**Planning Department
Transportation Development Services**

November 24, 2015

**Re: GAHP Casa Feliz, Buildings A-L
441 Espanola SE
Traffic Circulation Layout
Engineer's/Architect's Stamp dated 10-16-15 (L19-D073A-I)**

Based upon the information provided in your submittal received 11-23-15, the above referenced plan cannot be approved for Building Permit until the following comments are addressed:

ENLARGED
TRAFFIC CIRCULATION
LAYOUT
BUILDING A

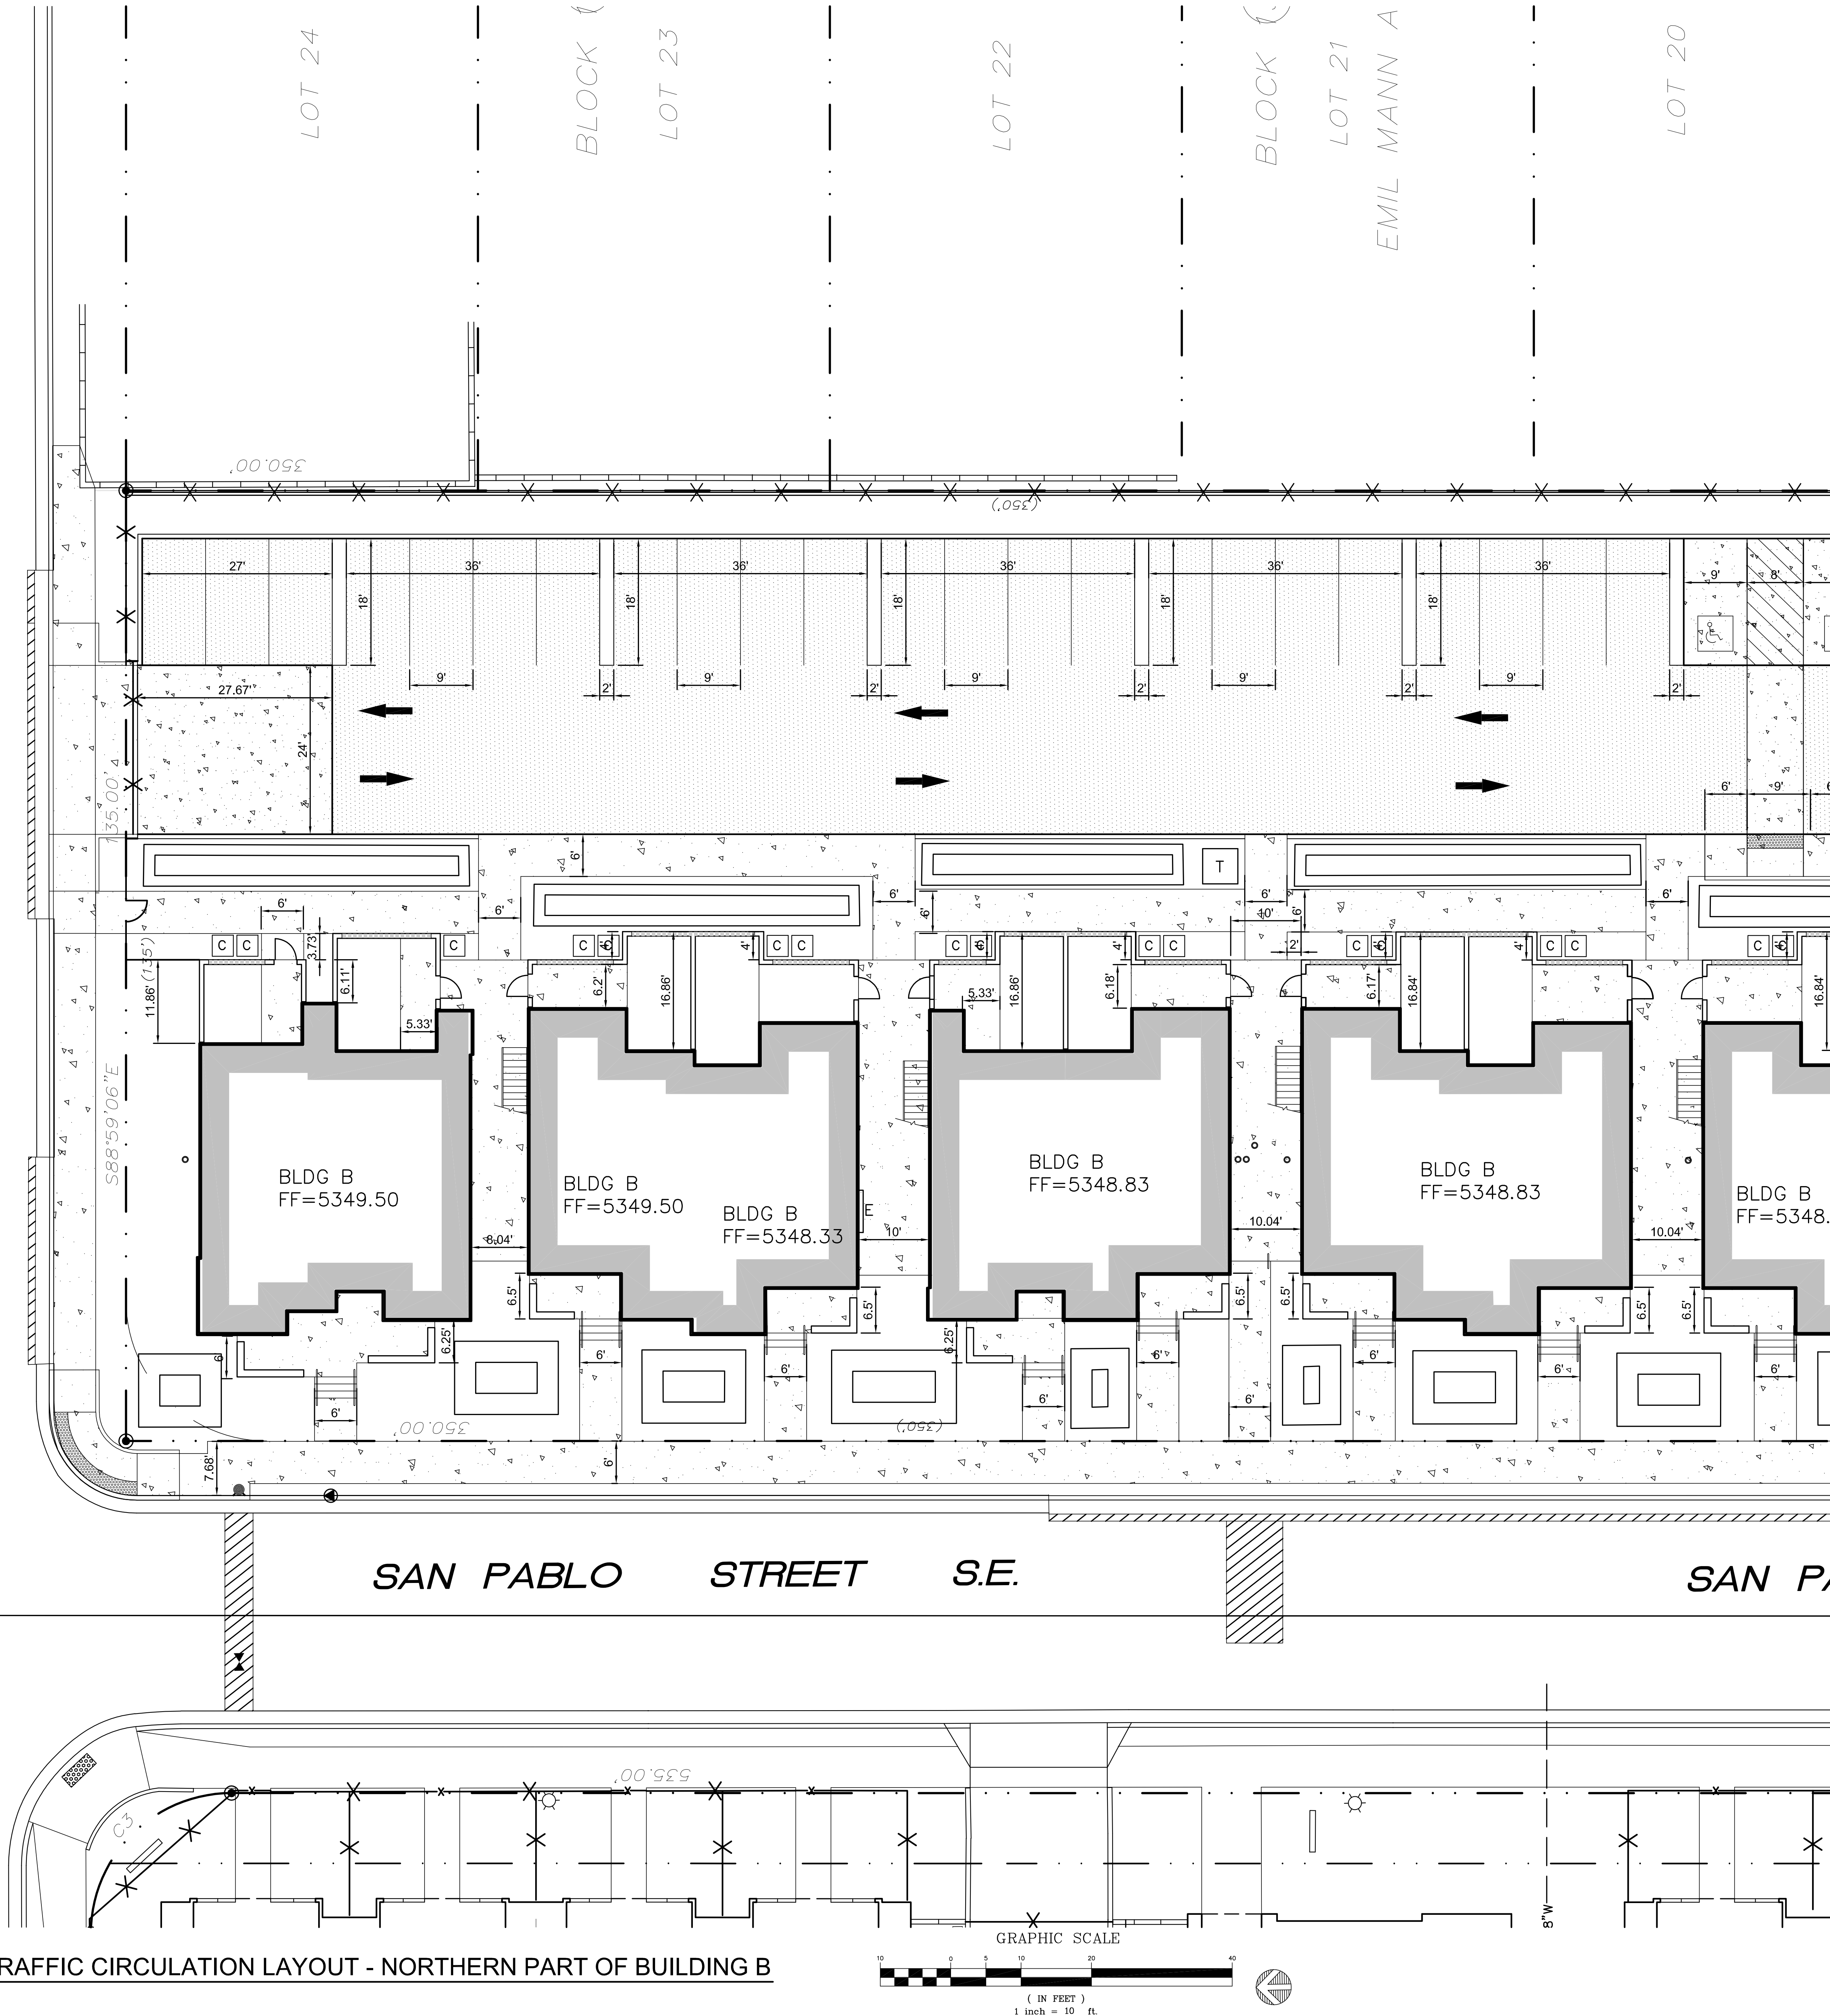
- Bldg. A: The drive pad entrance off of Trumbell Ave. must be a min. of 24 ft. in width for two way access.
 - Bldg. H: The drive pad entrance off of Espanola St. must be a min. of 24 ft. in width for two way access.

A1 ENLARGED TRAFFIC CIRCULATION LAYOUT - BUILDING I

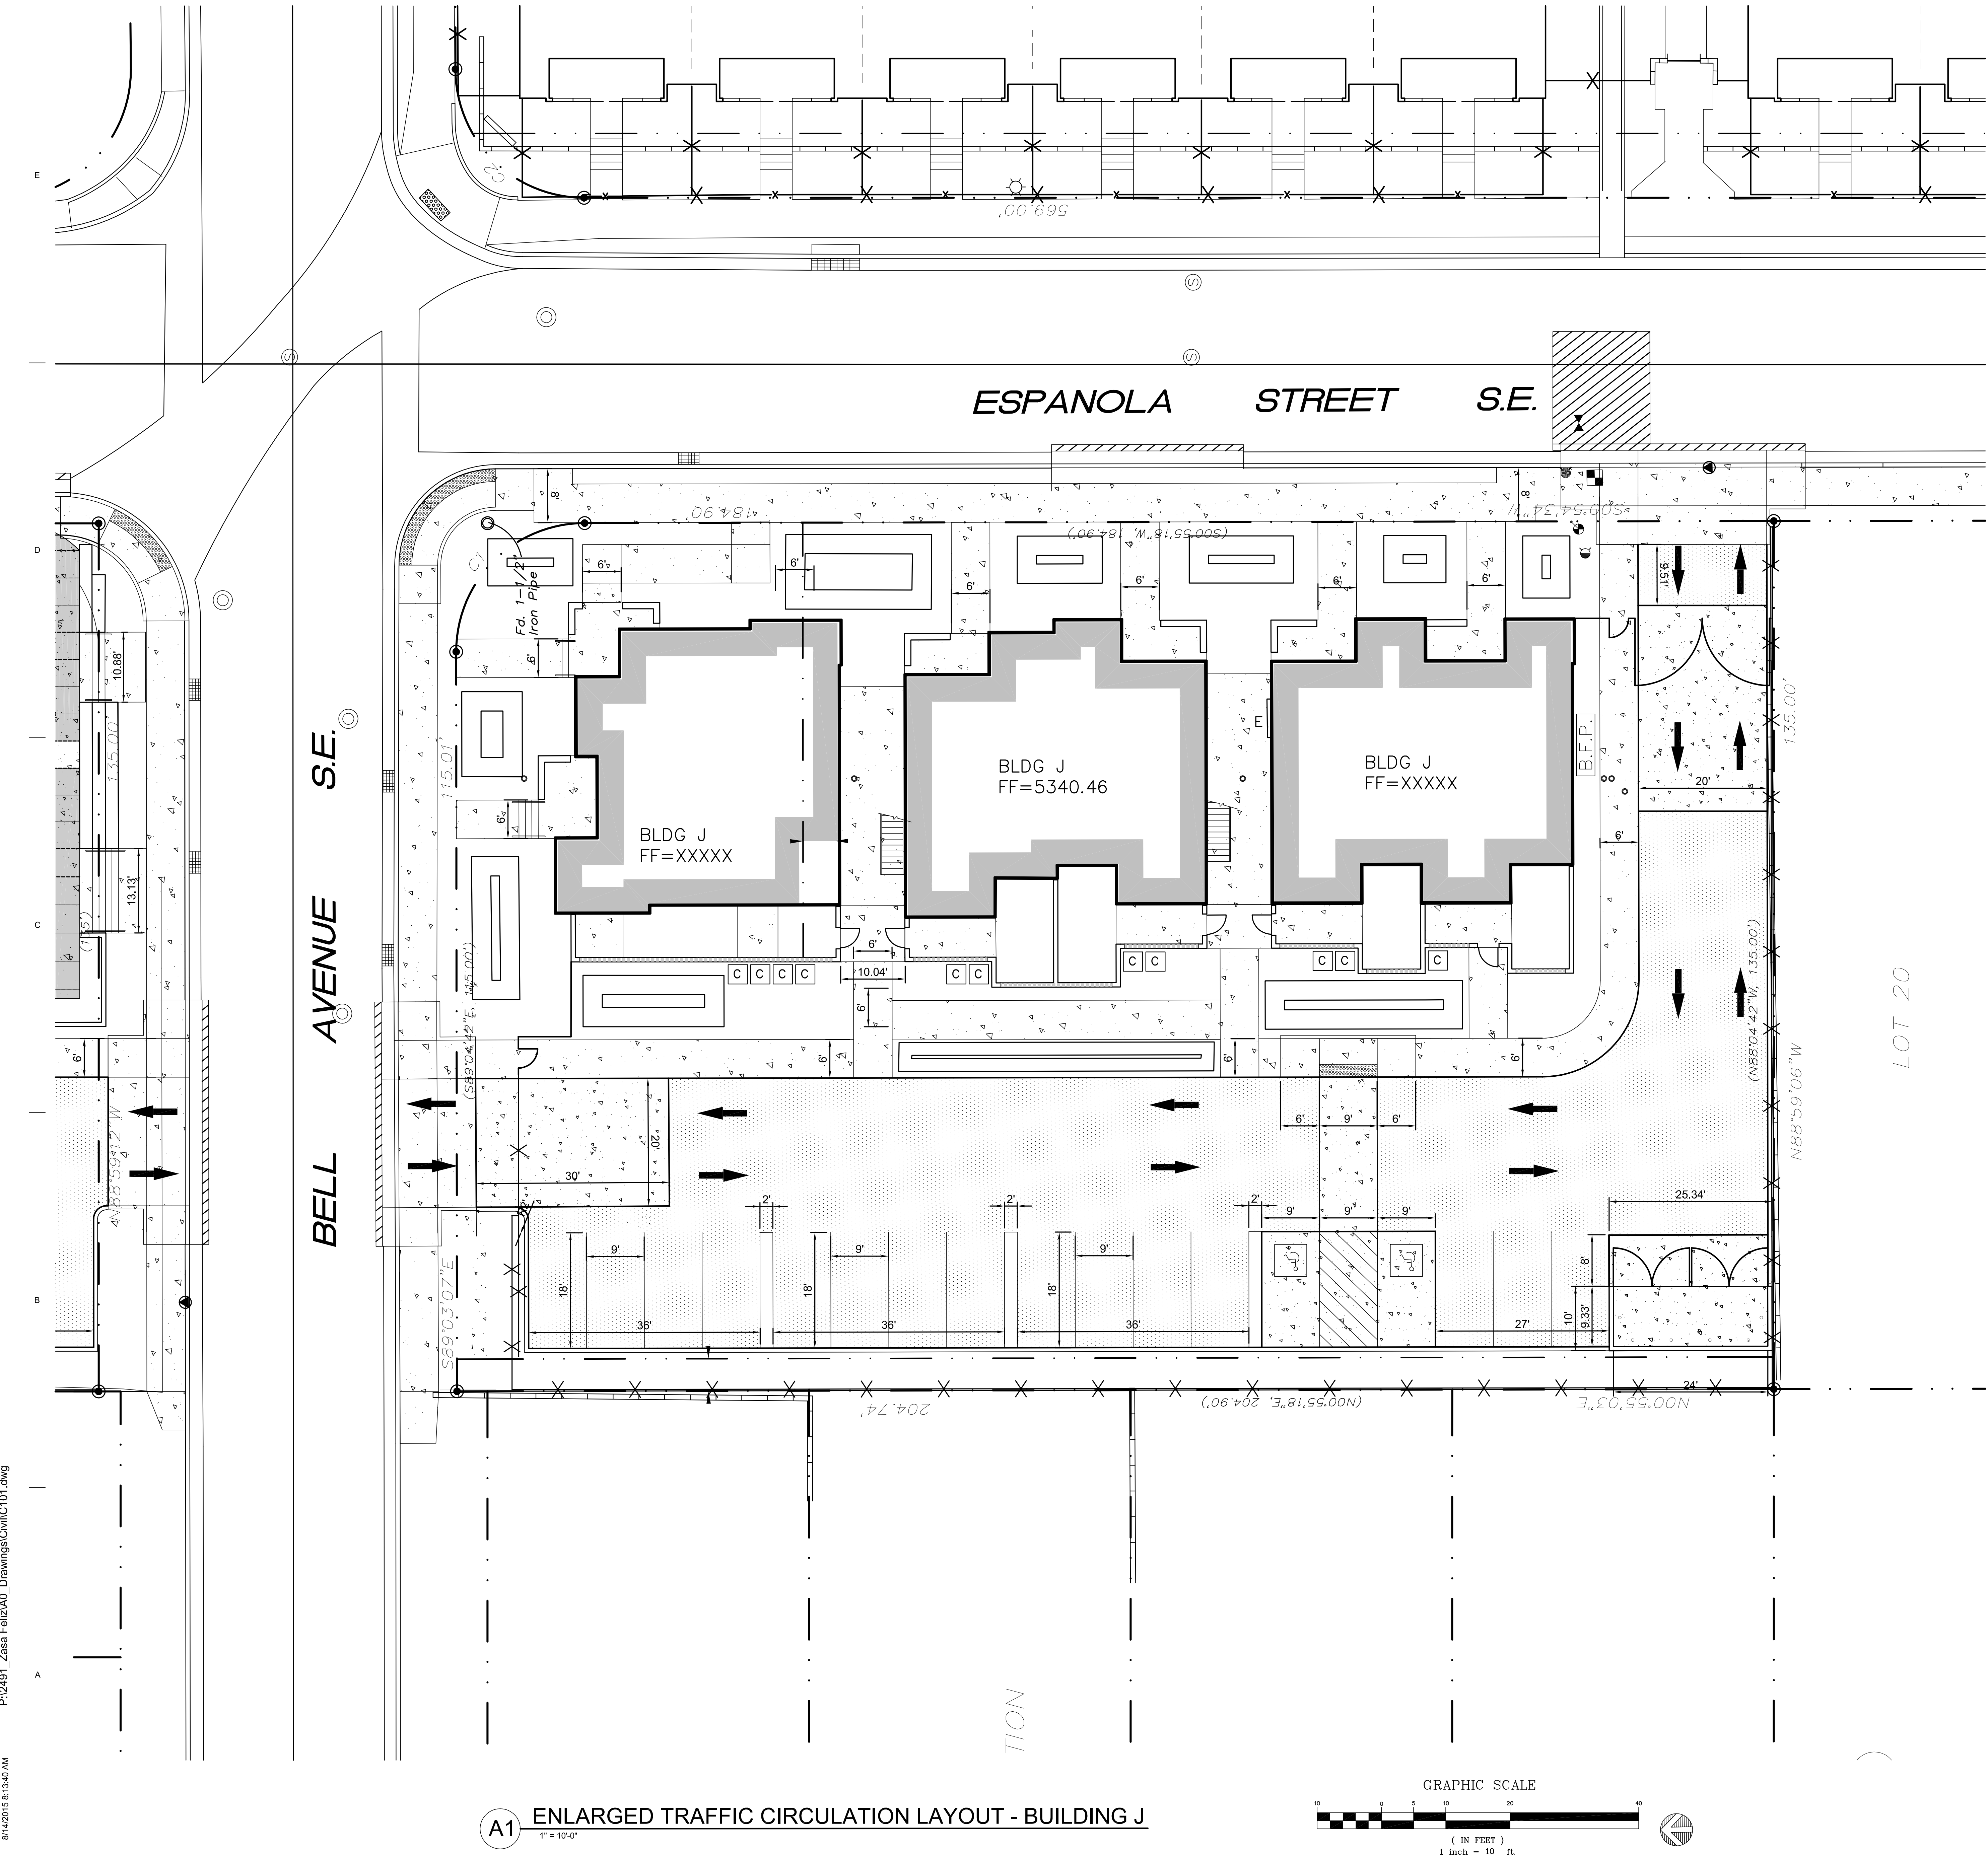
- Bldg. I: The drive pad entrance off of Bell St. must be a min. of 24 ft. in width for two way access.
 - Bldg. J: The drive pad entrance off of Bell St. must be a min. of 24 ft. in width for two way access.

ENLARGED
TRAFFIC CIRCULATION
LAYOUT
BUILDING K

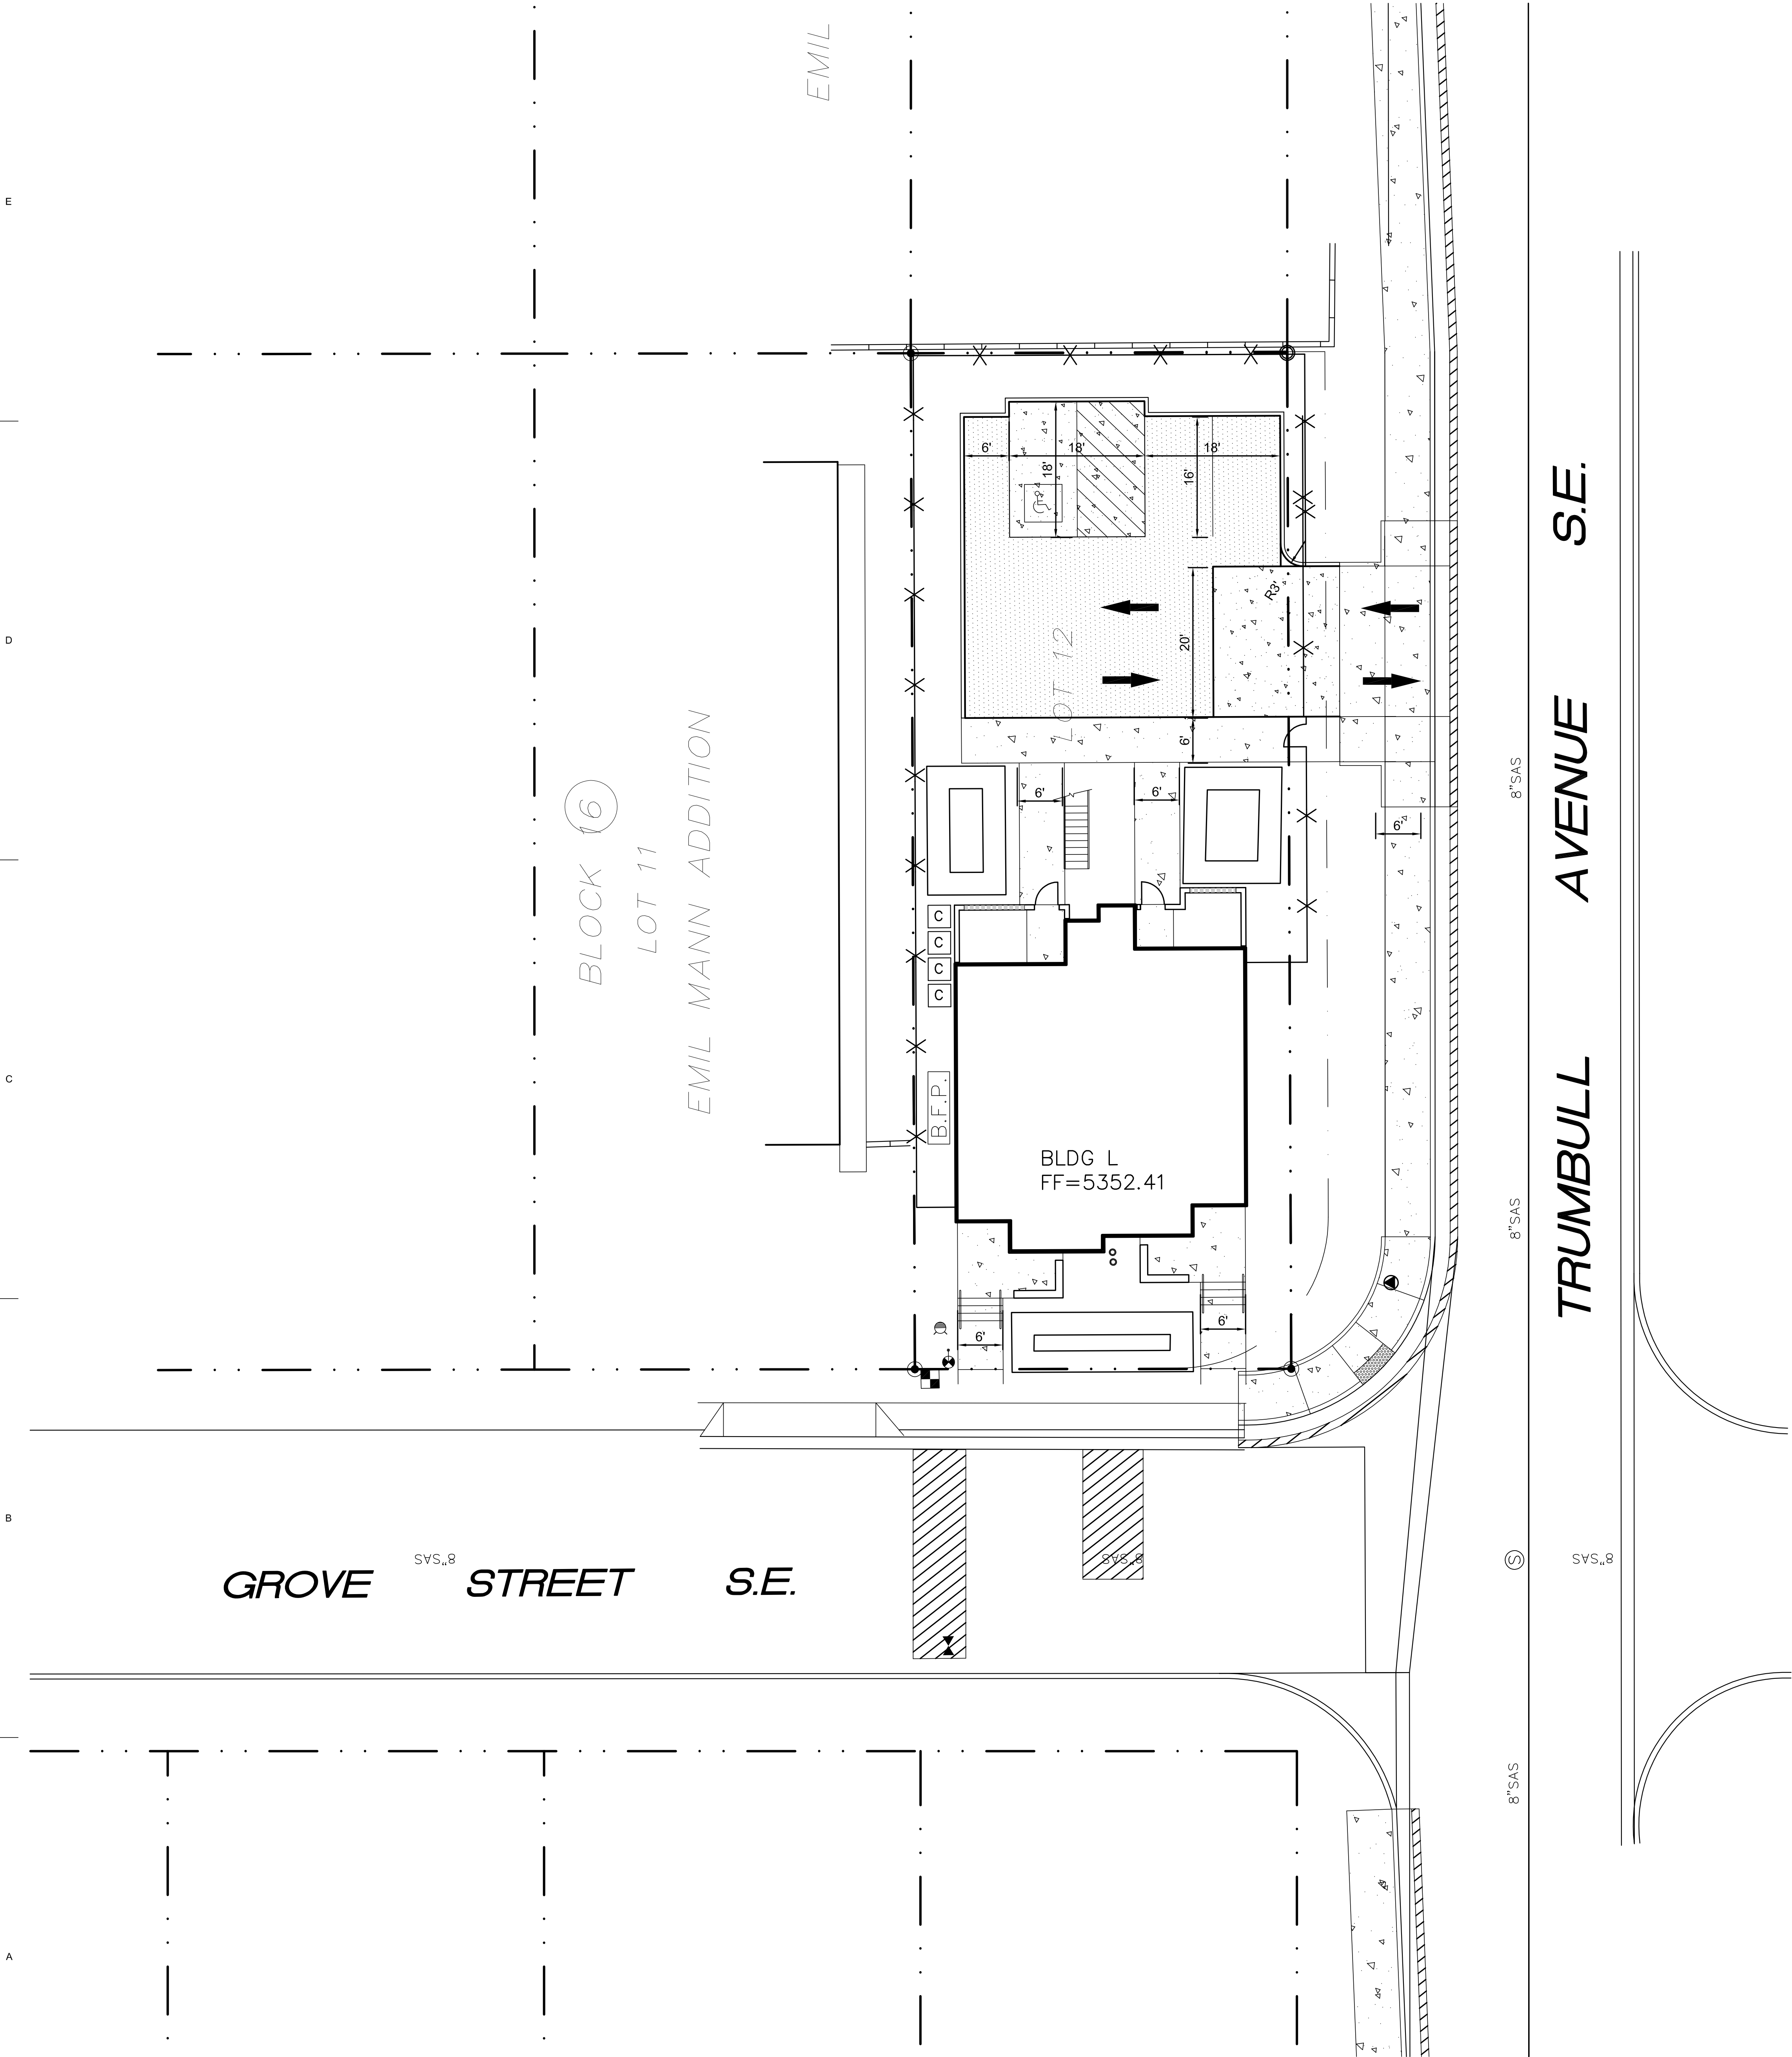
- Bldg. K: The drive pad entrance off of Espanola St. must be a min. of 24 ft. in width for two way access.
 - Bldg. L: The drive pad entrance off of Trumbell Ave. must be a min. of 24 ft. in width for two way access.
